From: Patz, Logan W.
To: ["architractors@aol.com"](mailto:architractors@aol.com)
Cc: [Ortiz, Monica](#); [Biazar, Shahab](#)
Subject: Casitas De Albq. K13D075Fire Access off Lead Ave.
Date: Tuesday, July 18, 2017 11:09:00 AM

After review of the Building permit for 1016 Lead Ave. it has come to our attention that the entrance to the site off Lead Ave. is intended for Fire and emergency access ONLY. This will need to be reflected on the site plan and identified at the site that the access is for emergency use only.

SITE PLAN

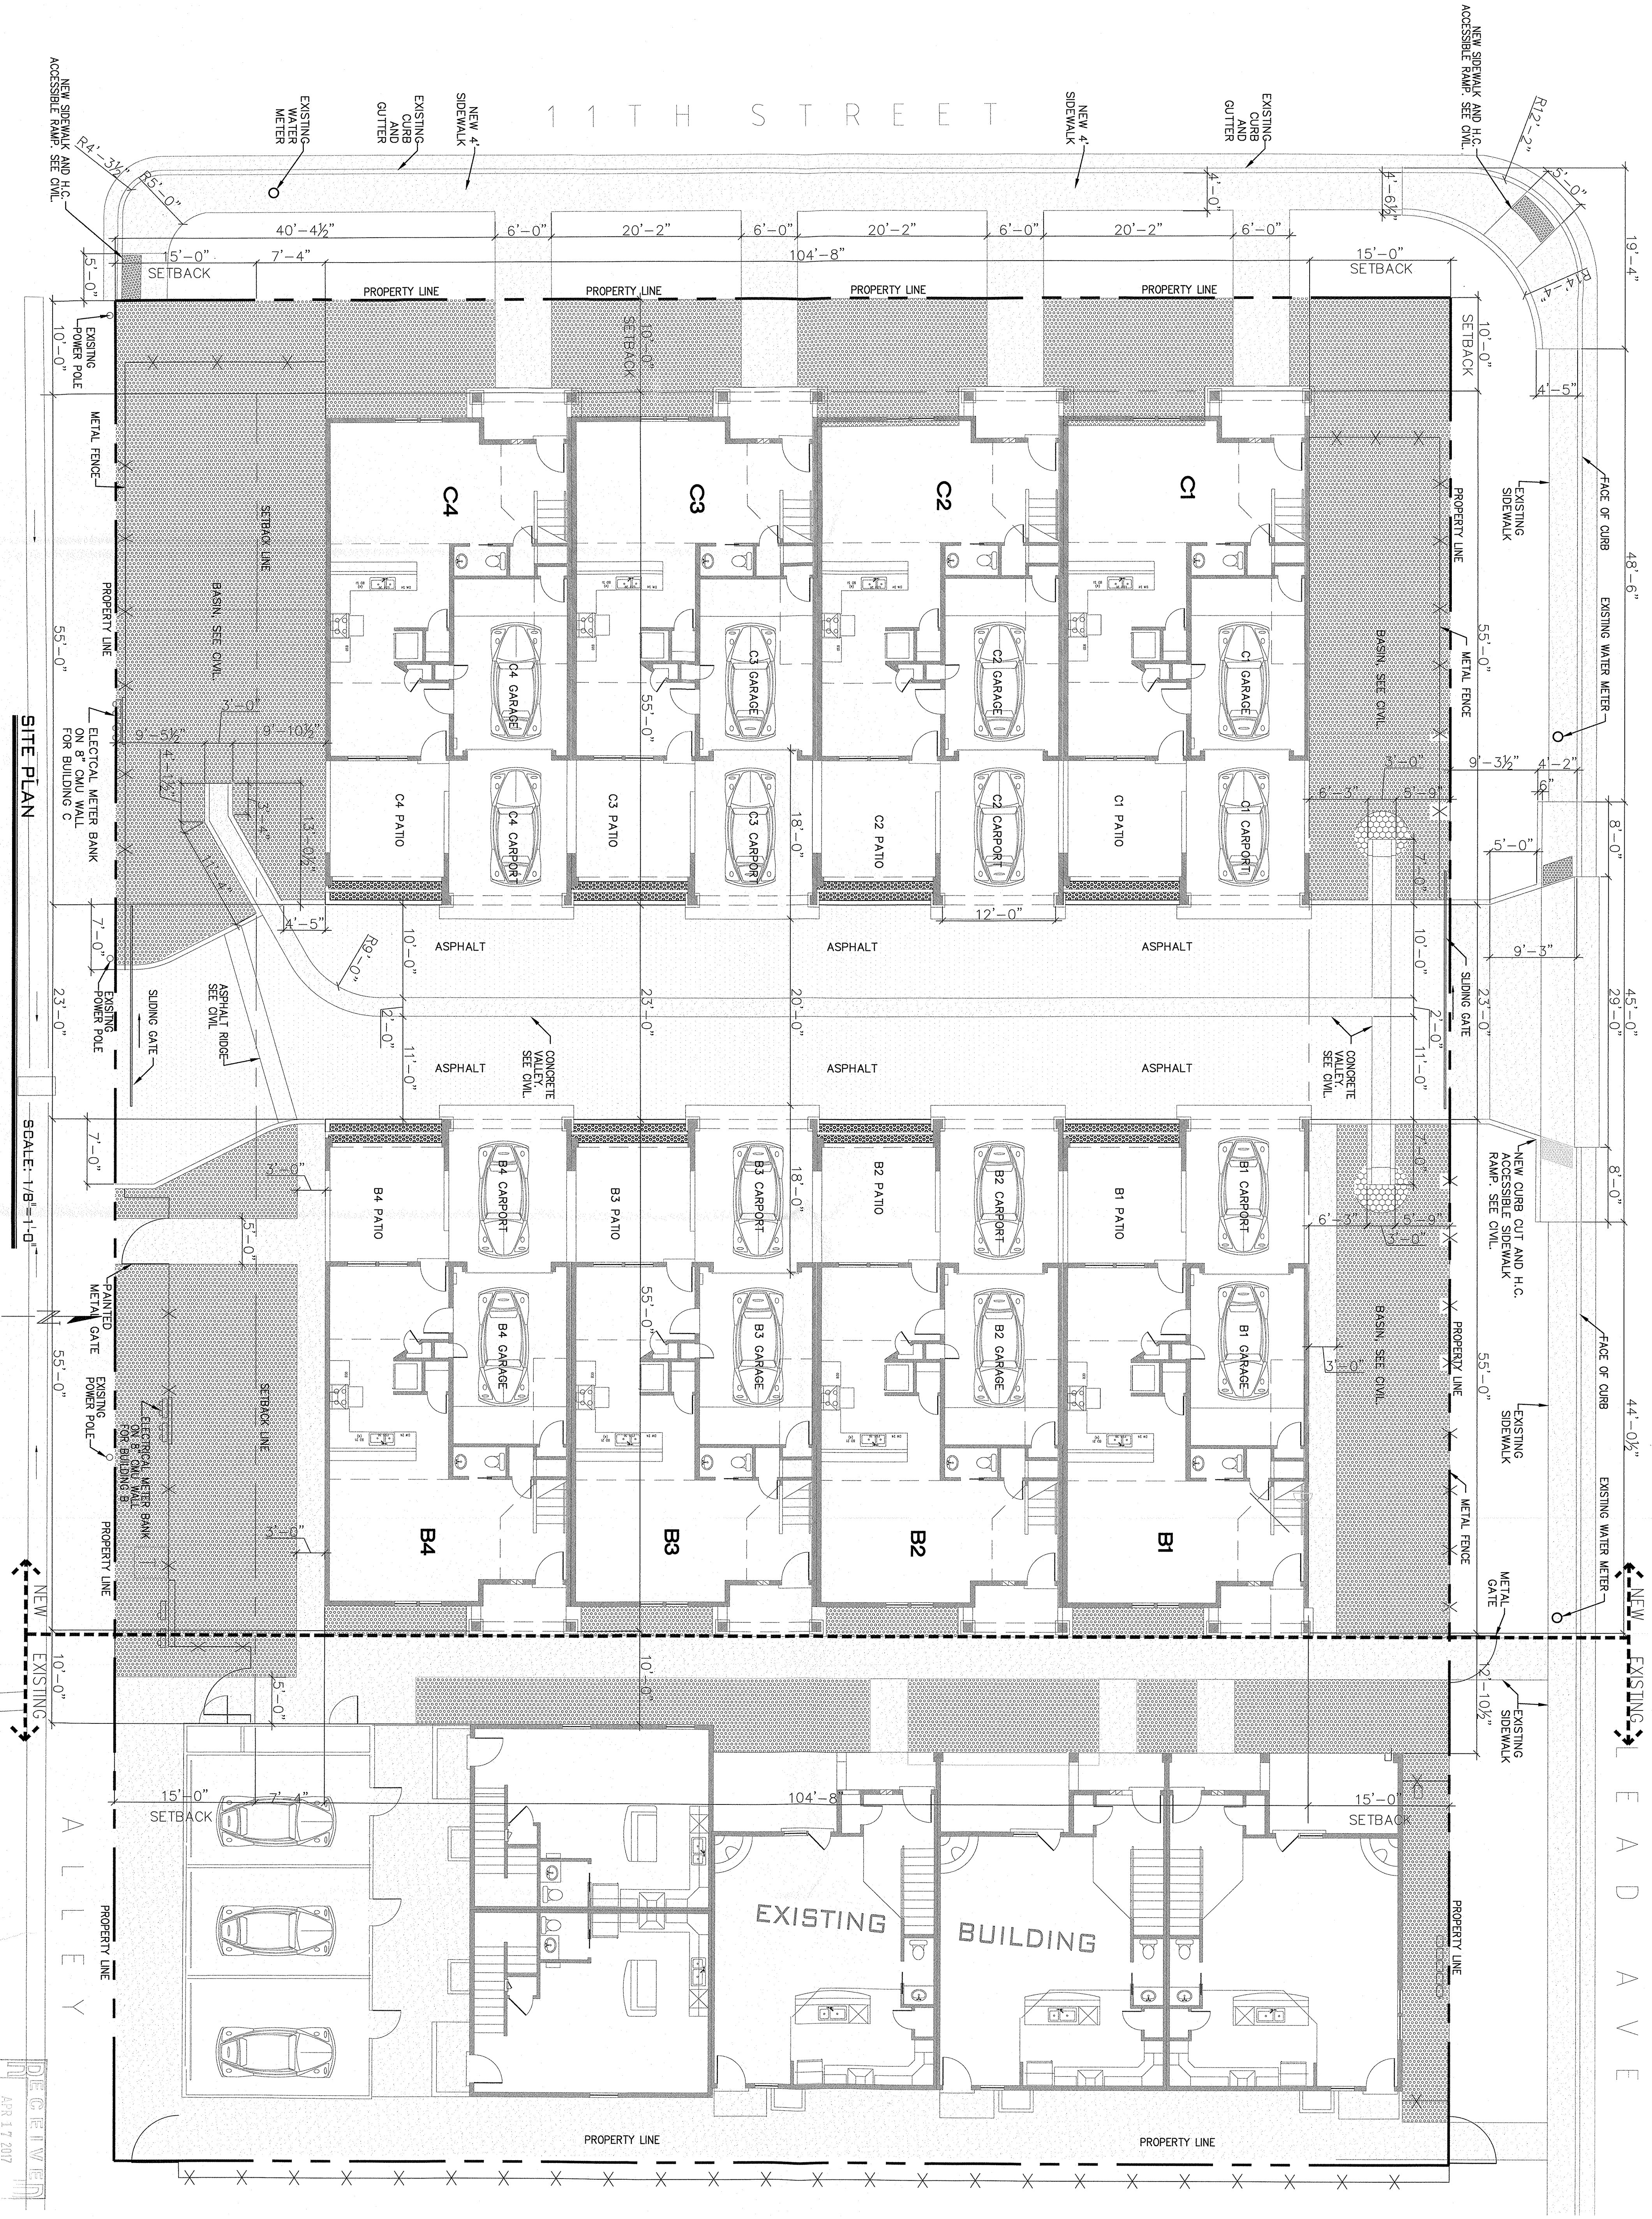
You may come in and redline the plans to reflect the emergency access on the building permit plan set. This will be a requirement for building permit. Please call me if you have any questions.
